RE: SECTION 4.55(2) MODIFICATION TO SSD 7709 – PROPOSED MOOREBANK INTERMODAL PRECINCT WEST – STAGE 2 – SSD 7709 MOD 1

PROPERTY AT: MOOREBANK AVENUE, MOOREBANK (LOT 1 DP 1197707)

Table 1: Response Matrix

Figure 4: Extent of enclosure for JR rooftop air handling units

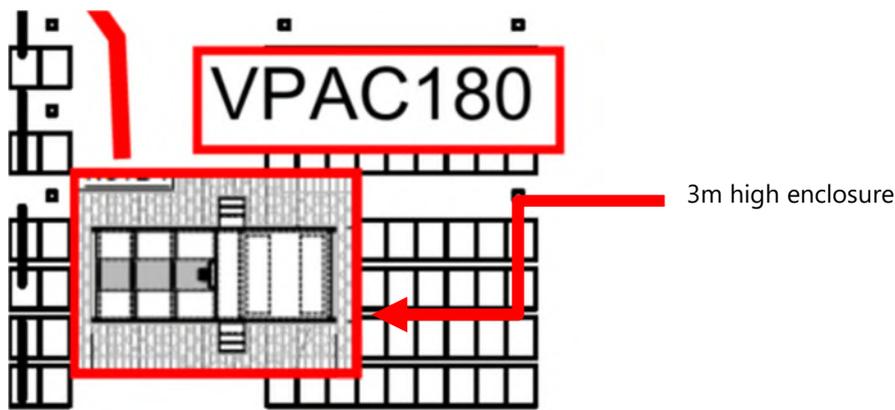
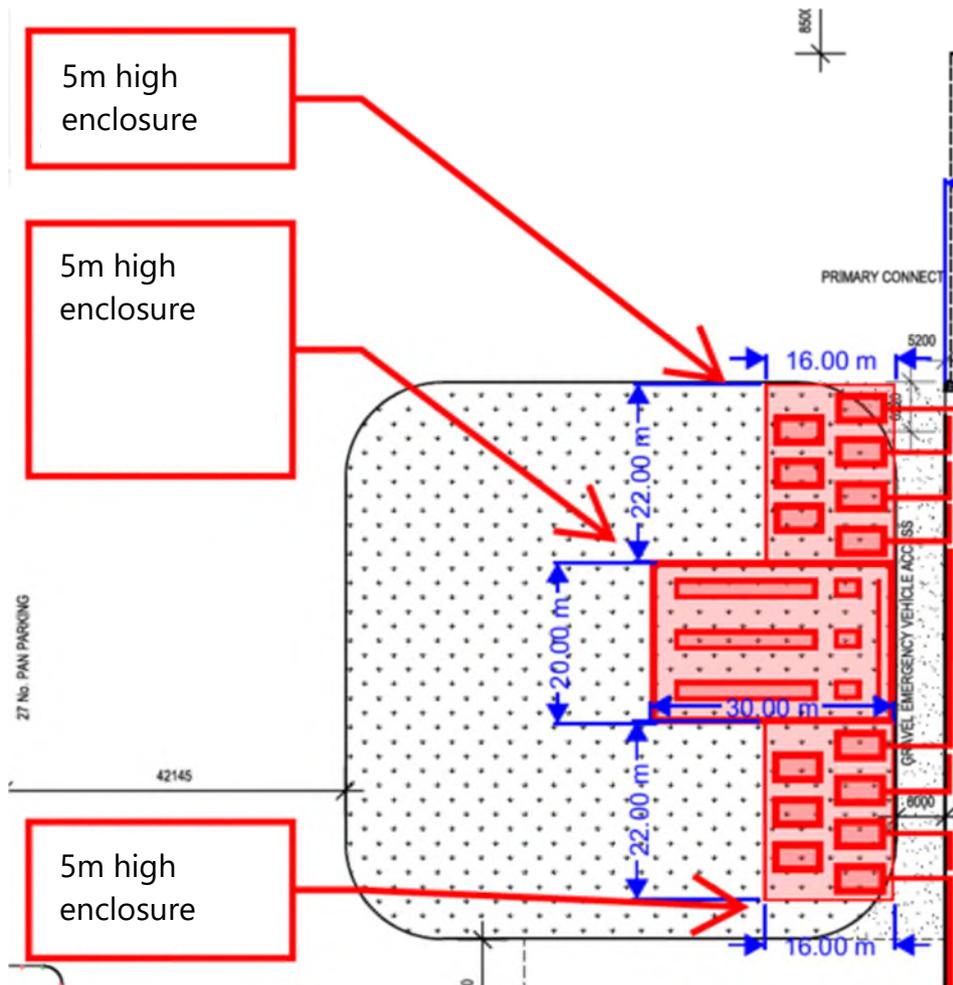
The modification involves a height increase from 21m to 45m. A rooftop mechanical plant is proposed at 45m although the locations are not yet finalized. The rooftop plant will be enclosed within 4 walls with no roof.

Although the report identifies mechanical plant as a main noise source, it does not indicate whether the source has been considered at 45m roof level and if that noise will be shielded by the noise wall.

The report does not indicate whether noise propagation to receivers through the roofless enclosure will be affected by the adverse meteorological conditions. It is also possible that Sleep Disturbance may occur when the enclosure door is momentarily opened for access. These items should be considered in the next run of the model and in the upcoming mechanical plant noise assessment.

In-principle recommendations are provided in this assessment to manage potential impact of noise generated by construction and operation activities to be considered for inclusion within the site's Operational Noise Management Plan, as required under condition B136.

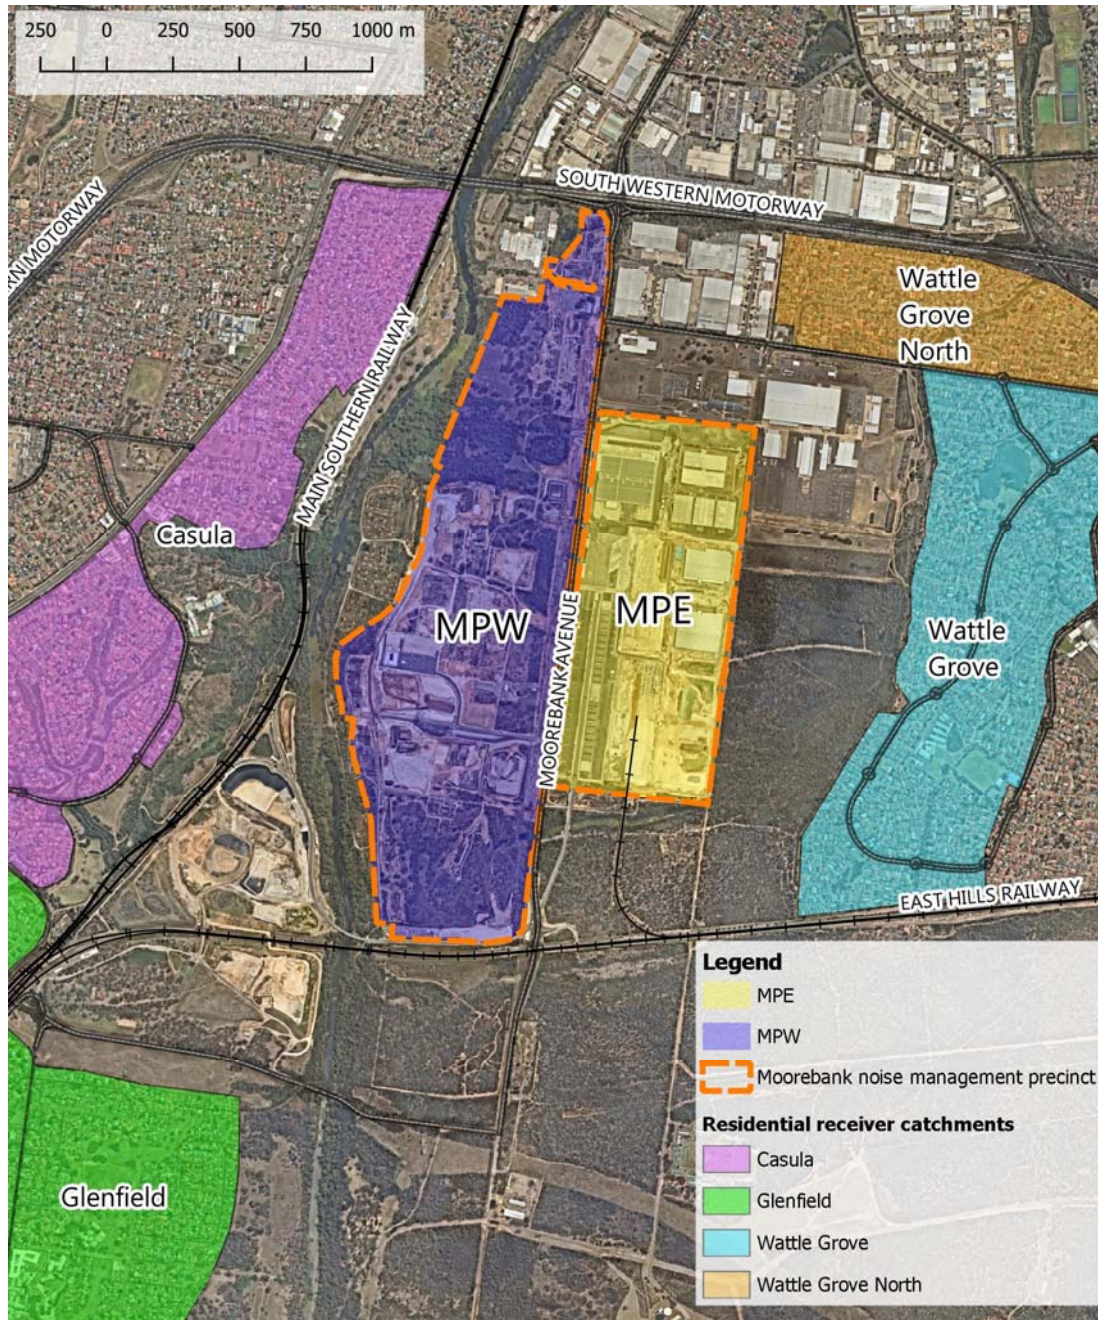
The modified noise limits would apply to the relevant operational noise sources within the Moorebank Noise Management Precinct boundary shown in Fig 5-1. These modified noise limits would apply under prevailing meteorological conditions presented in Section 5.2.1.5.

As mentioned above, Renzo Tonin note and agree to the comments made by Northrop. However, they recommend that the revised noise limits included in the RtS are adopted for the subject Modification Application. These are presented in Table 2-3, which added a morning shoulder period following an analysis of the EIS monitoring data (refer to **Appendix 4** for consistency and completeness).
